Inspector's Addendum Report ABP-320049-24

Construct 267 residential units, a childcare facility, a link road, road upgrades along the Old Navan Road (R157) and associated development

Bennetstown, Pace & Dunboyne townlands, Dunboyne, County Meath

Drawing file: Applicant Further Information Response / f.i. terrace g - house type x floor plans.pdf

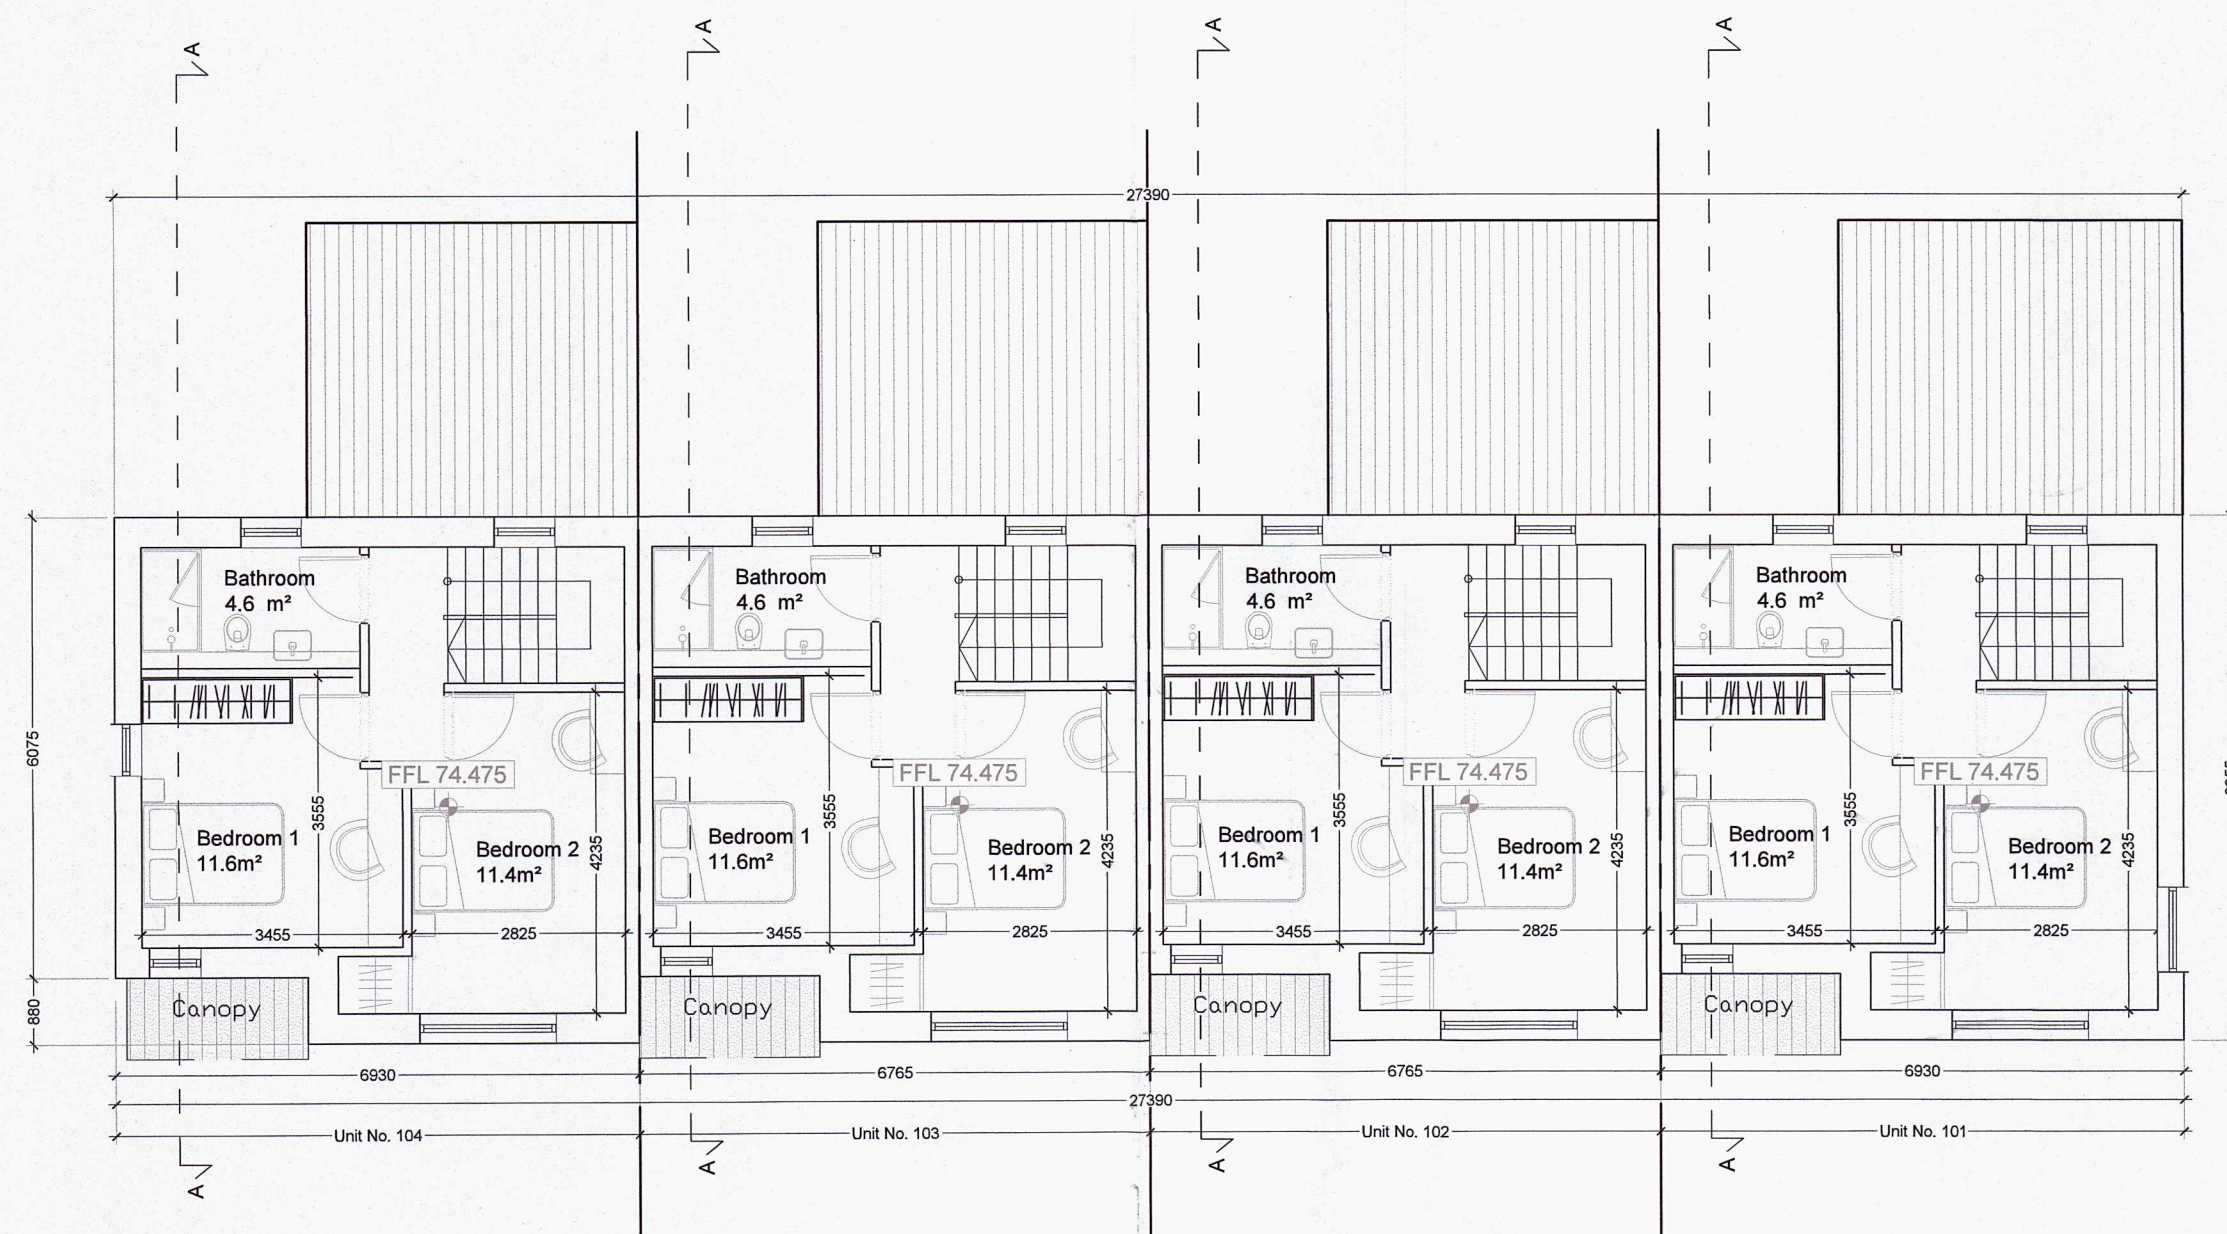
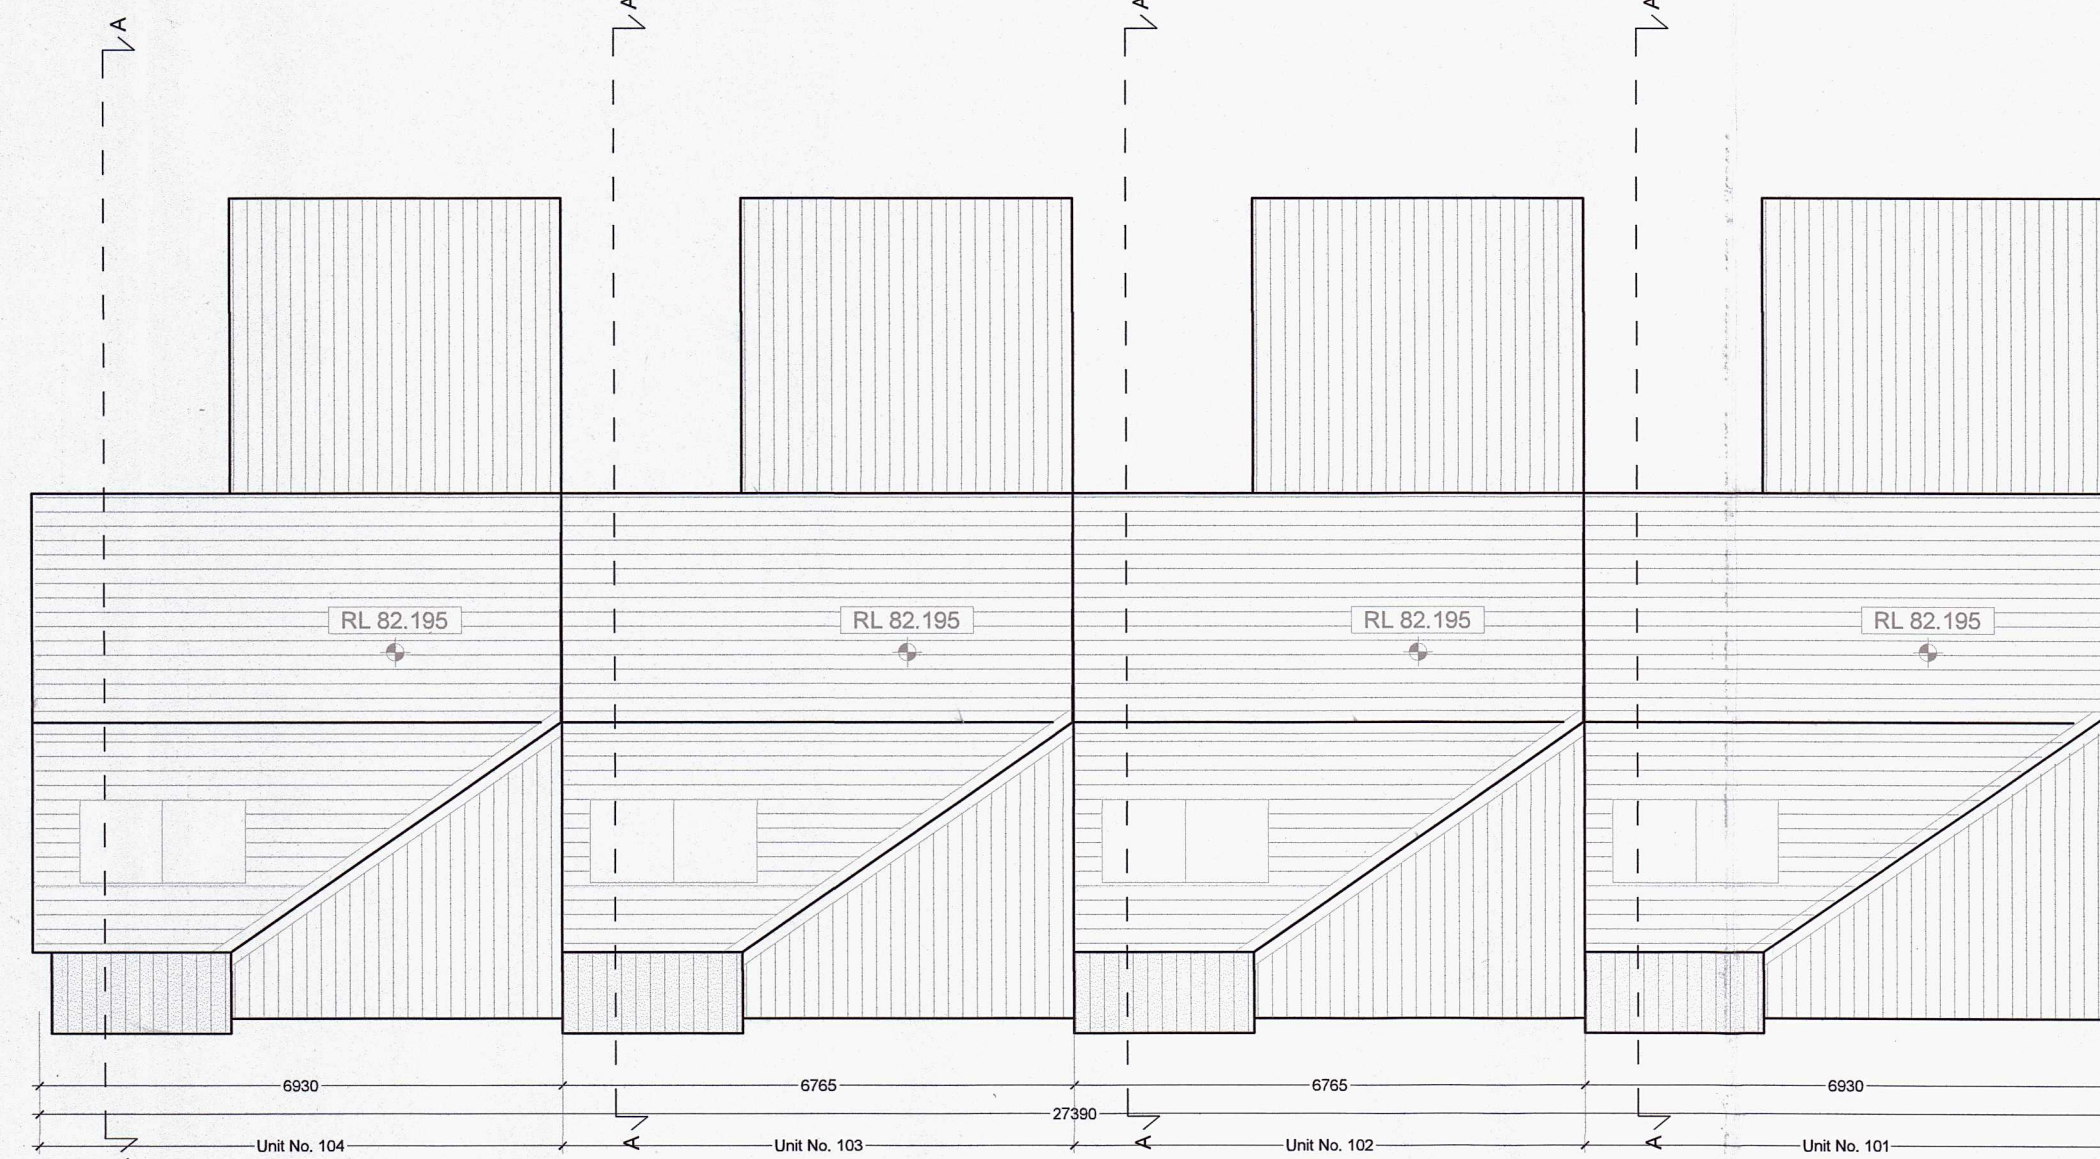
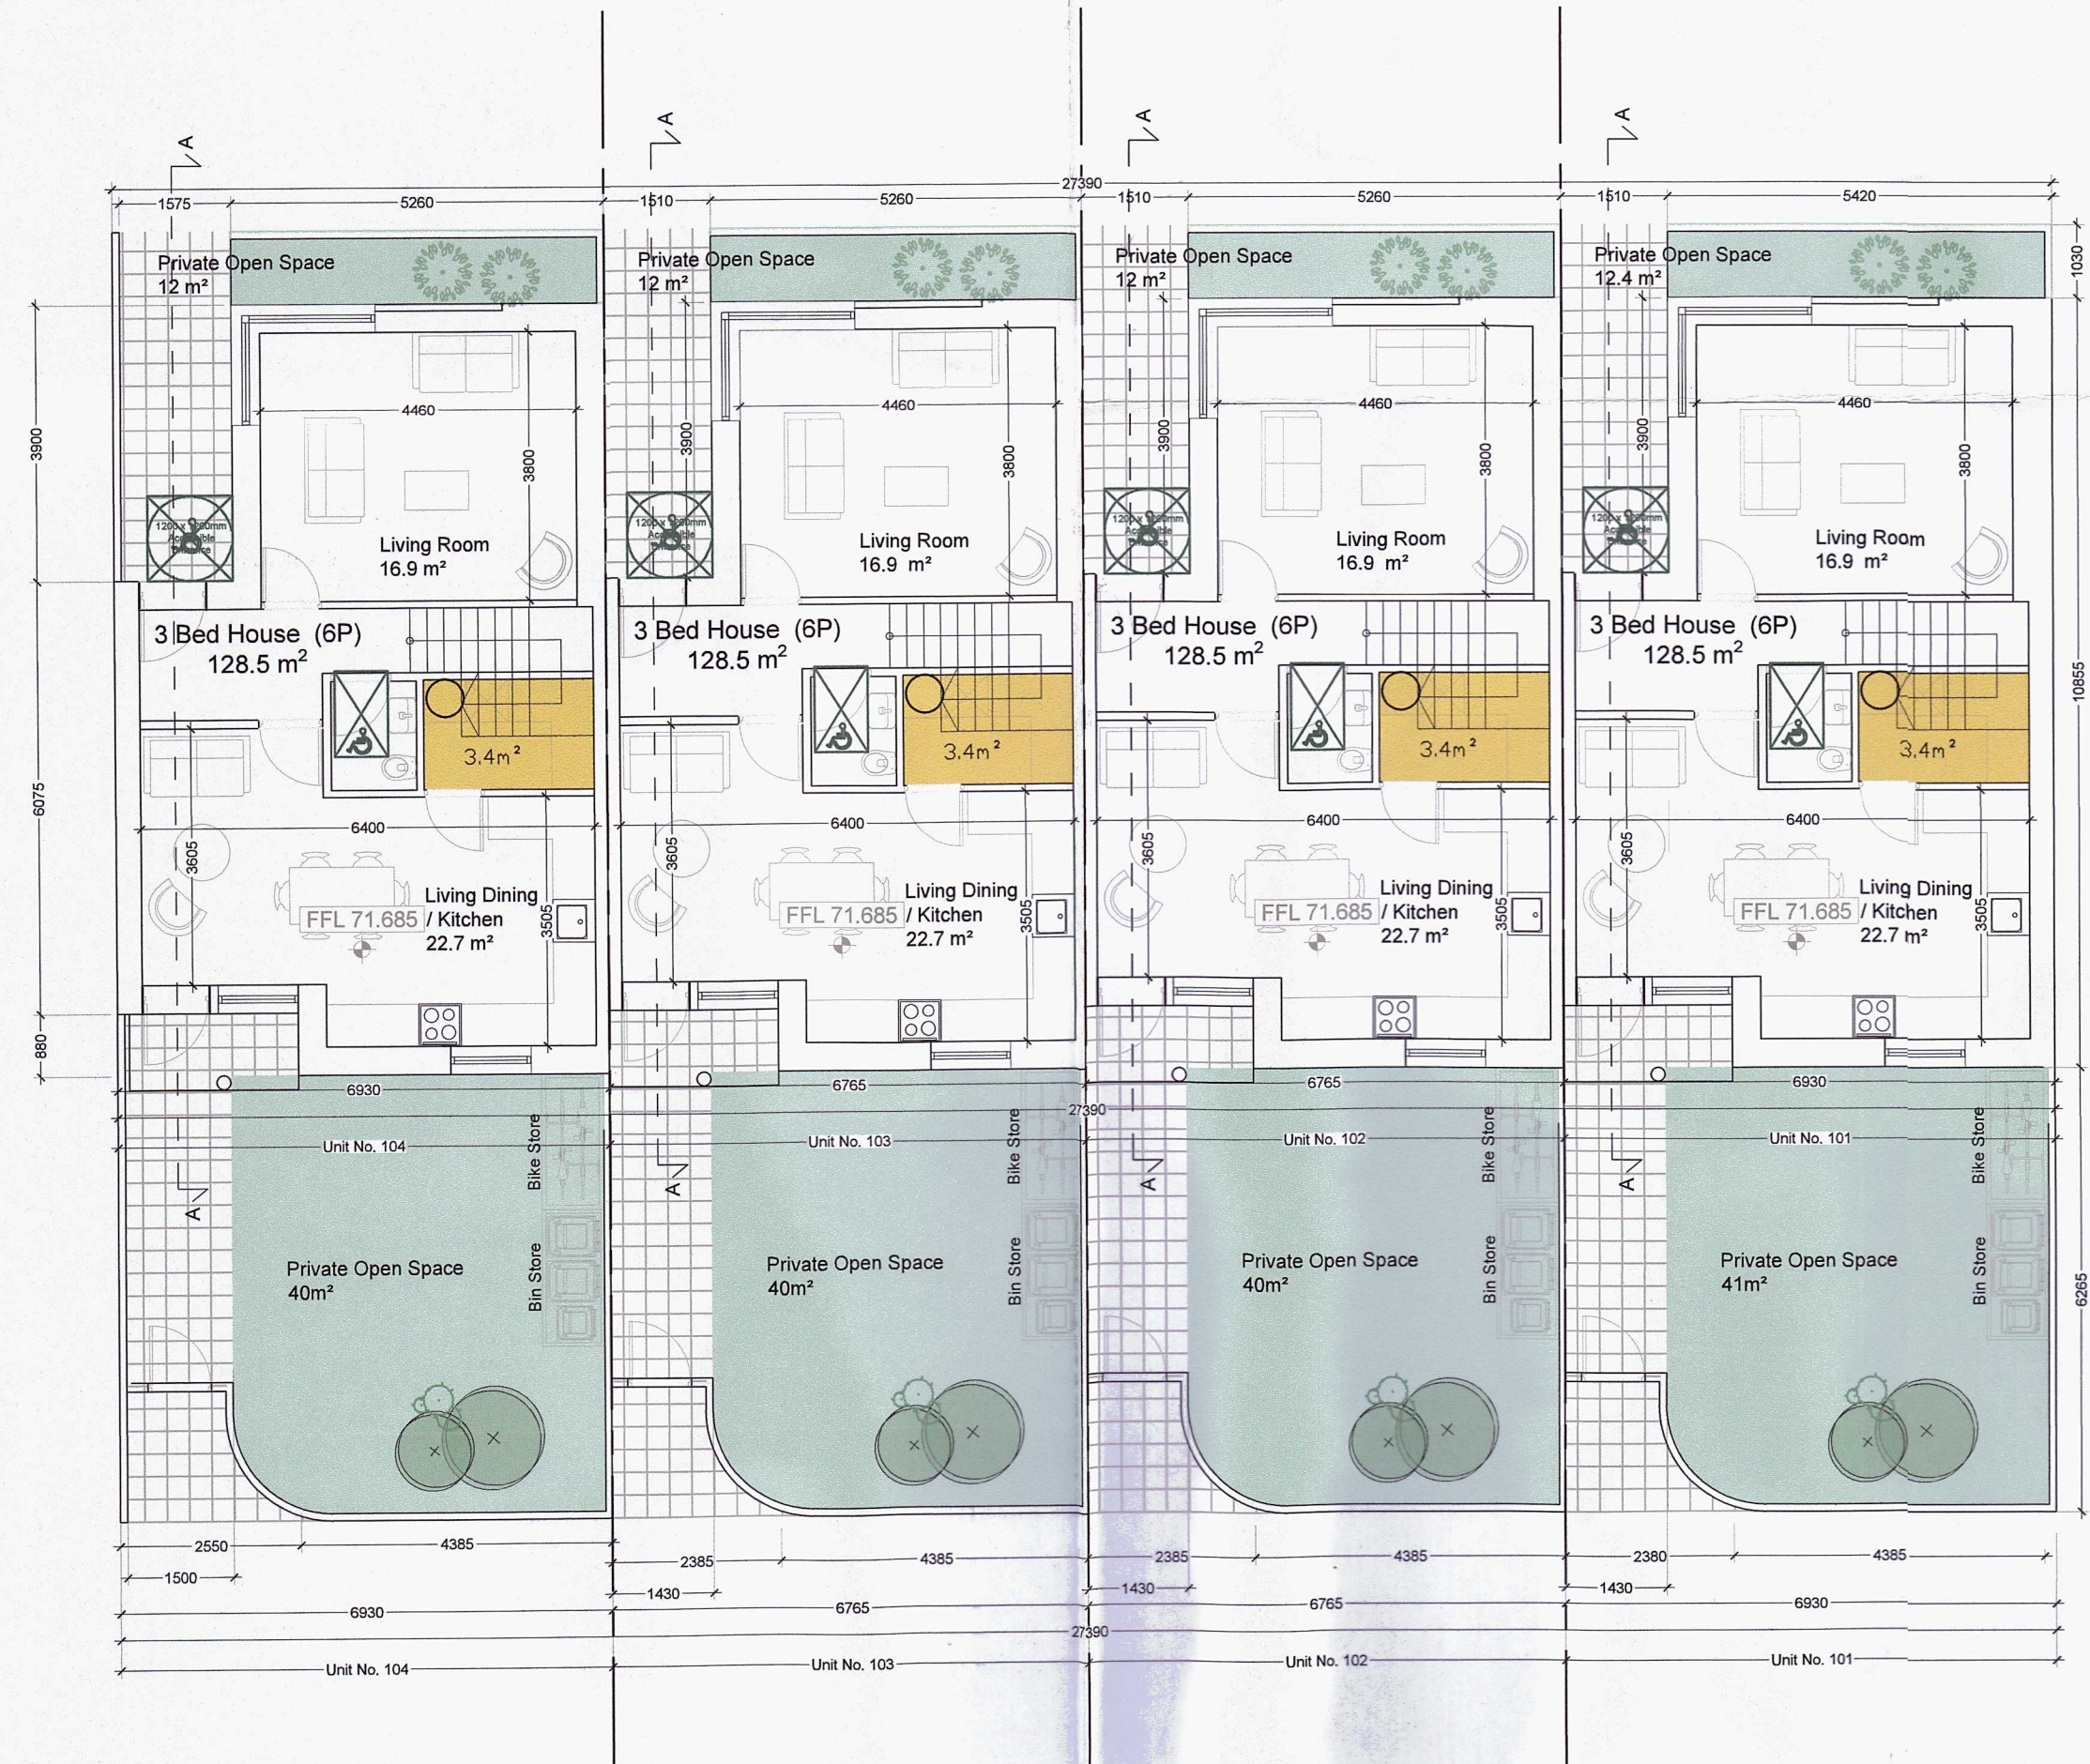
- 2.6.7. Consequently, with the exception of block G, integrated accessible communal space could be provided for the subject blocks in line with the provisions in SPPR 2 of the Guidelines. As noted, the minimum reduced provision of 20sq.m private open space for the subject townhouses would not be provided based on the plans presented in the application. Notwithstanding this, there would be scope for an additional 4.7sq.m of terrace or patio areas to be provided directly adjoining the rear of these units given their context and layout, with doorways opening directly onto these areas as part of the first-party's ground floor plans for the subject townhouses. With the provision of such terrace / patio areas, the proposals would align with the approach within the Guidelines to the provide innovative housing solutions, while also ensuring the townhouses in blocks D, E and F could comply with SPPR 2 of the Guidelines.

- 2.6.9. Given the layout constraints in providing directly accessible high-quality and integrated communal space for each of the four townhouses in block G, the proposed development would not achieve the necessary private amenity space standards for this block in line with SPPR 2 of the Guidelines. Accordingly, in the event of a grant of planning permission, I am satisfied that a condition should be attached omitting block G from the proposed development. It would appear most logical from a planning perspective for the resultant area arising from the omission of block G to be absorbed into the adjoining public open space serving neighbourhood cell E. The omission of block G would result in the development achieving a net density of 51 units per hectare, which would remain in line with Development Plan and National planning policy provisions.

4. The proposed development shall provide for a total of 263 residential units and shall be amended as follows:
 - (a) block G, including the private open space and communal space proposed to be associated with this block, shall be omitted from the proposed development, and the resultant area shall be landscaped as public open space and integrated with the adjoining public open space serving neighbourhood cell E of the proposed development;
